November 22, 2022

SH 16A/Snuffles St.
El Paso County

RE: Cottages @ Mesa Ridge - Subdivision and Development Plan - PPR2219

EL PASO COUNTY CONSTRUCTION DOCUMENTS
GEC NOTES & TYPICAL SECTIONS

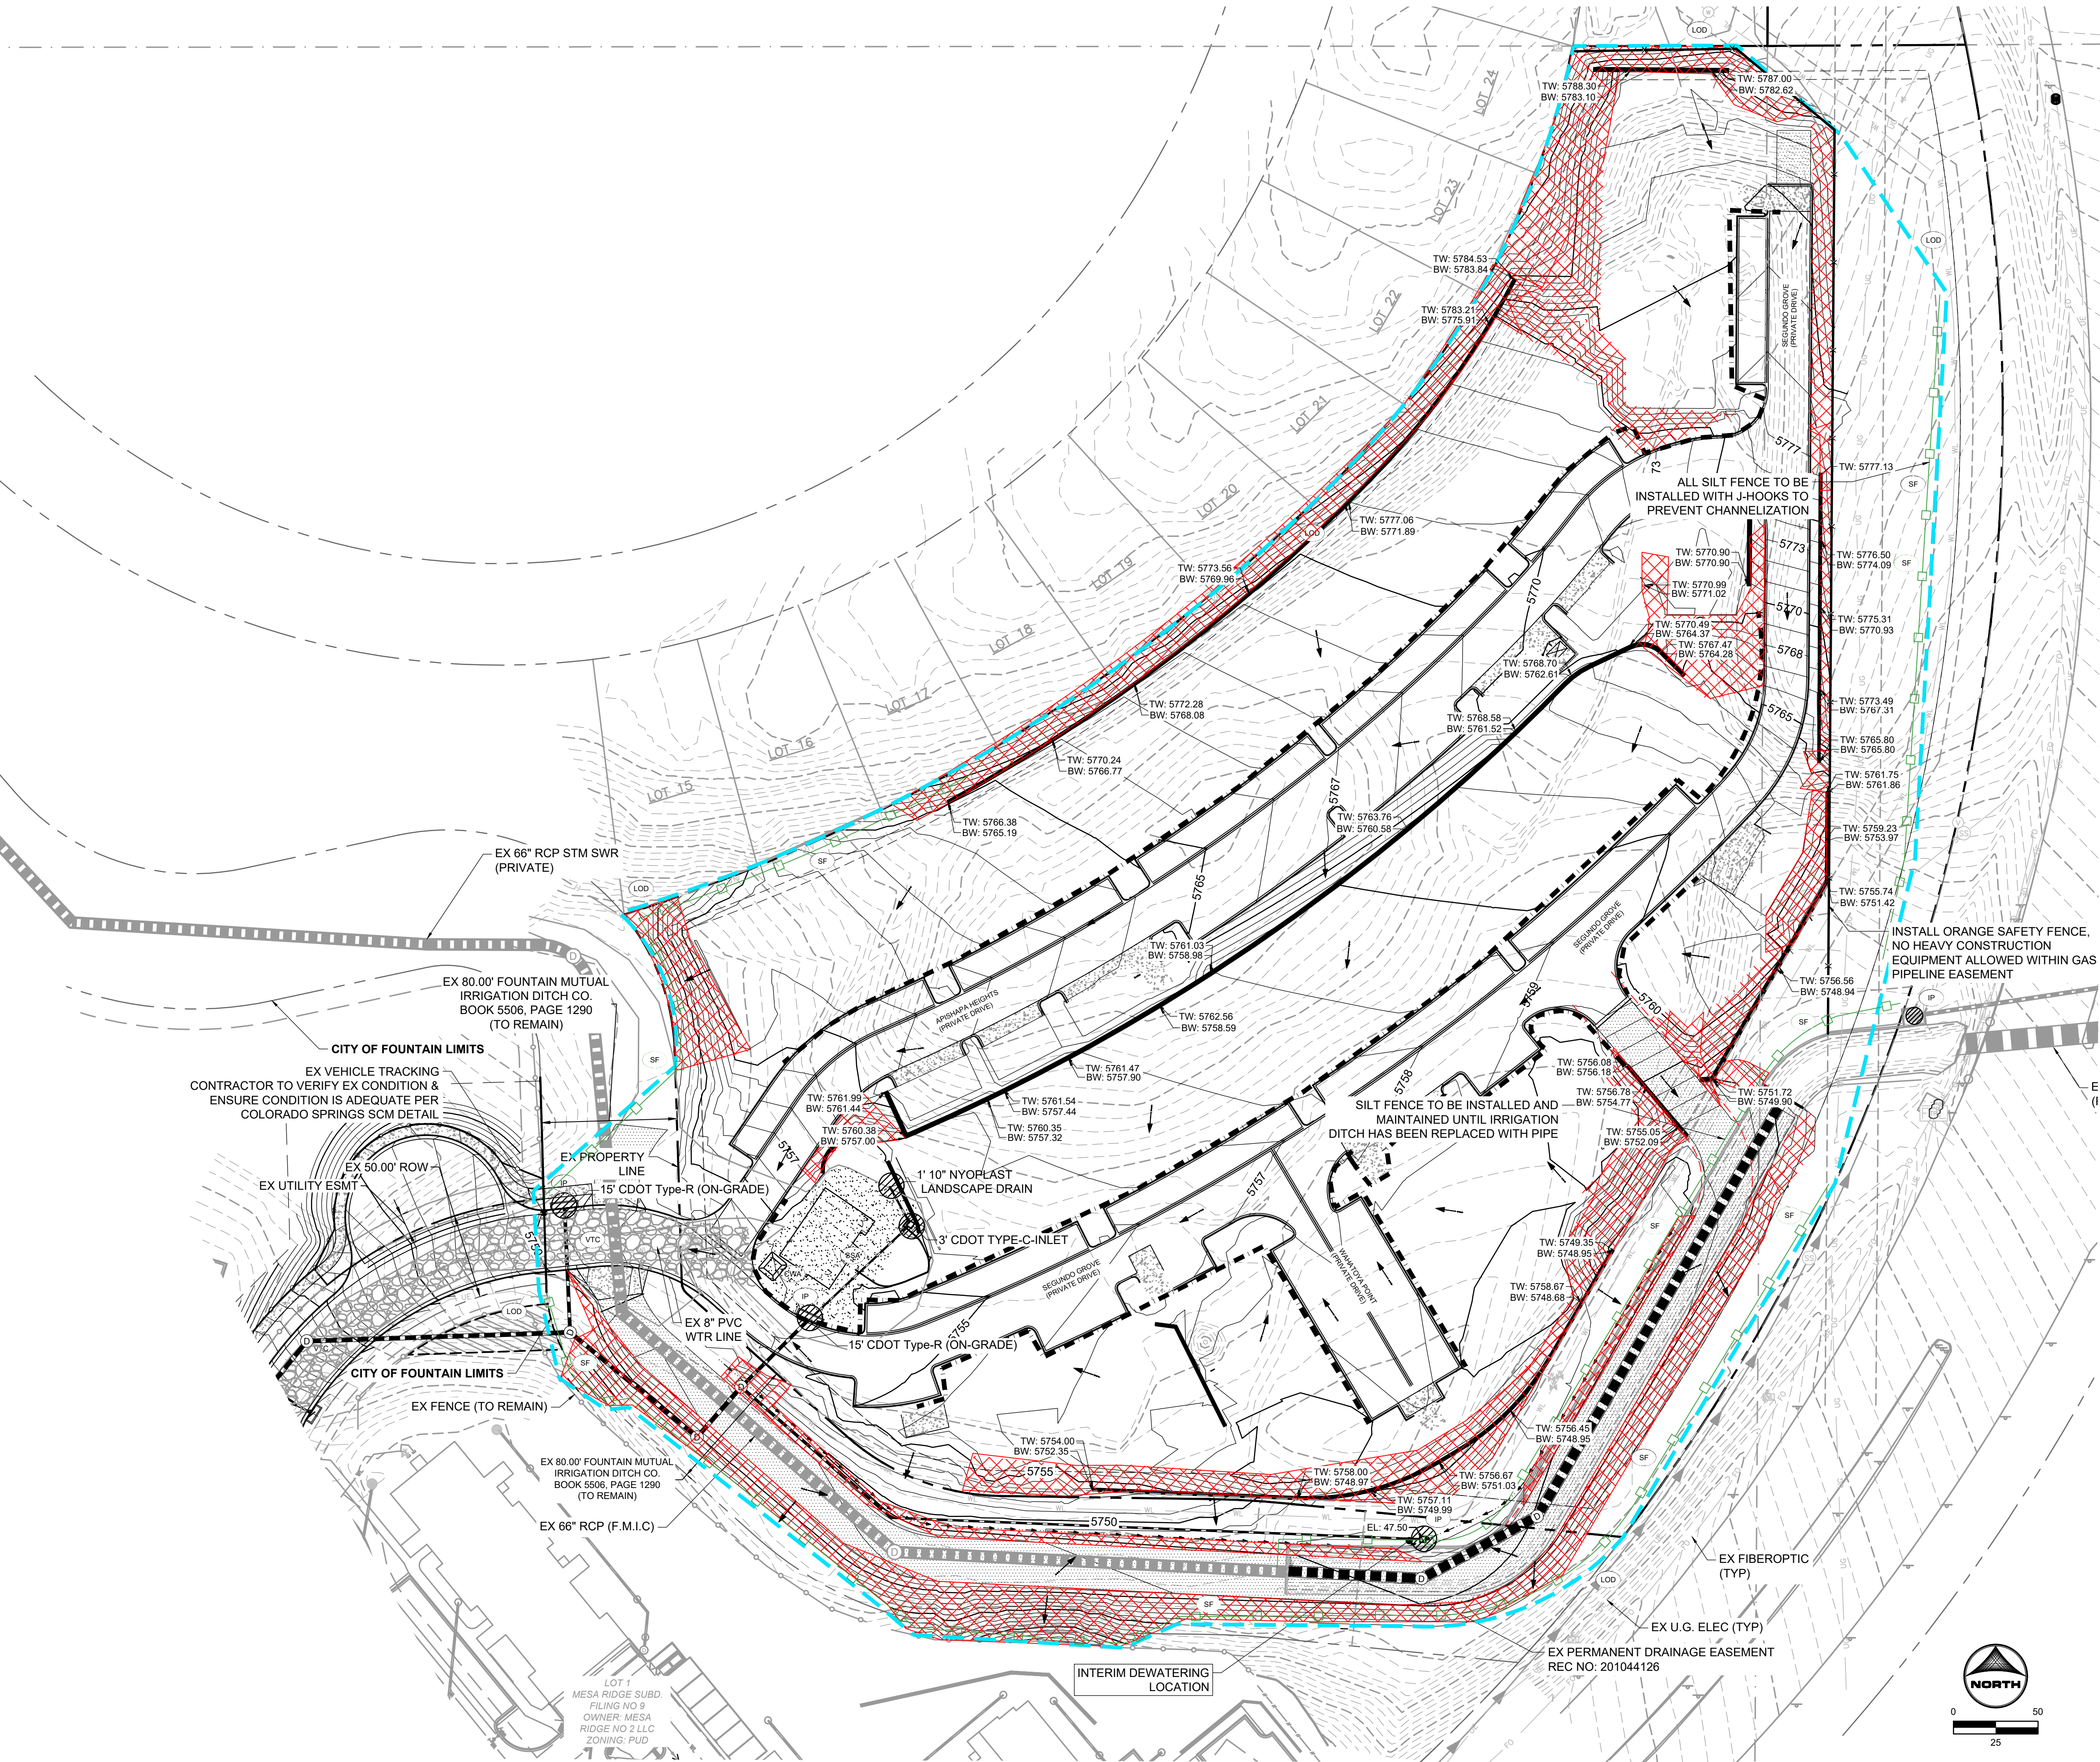
- Silt fence lines are missing from the El Paso County GEC-Interim Plan.
- Please provide protection for the existing 66" RCP storm line that passes under SH 21.
- Please provide flow arrows on the GEC plans.
- FYI: The El Paso County GEC-Vertical Plan is missing the border.
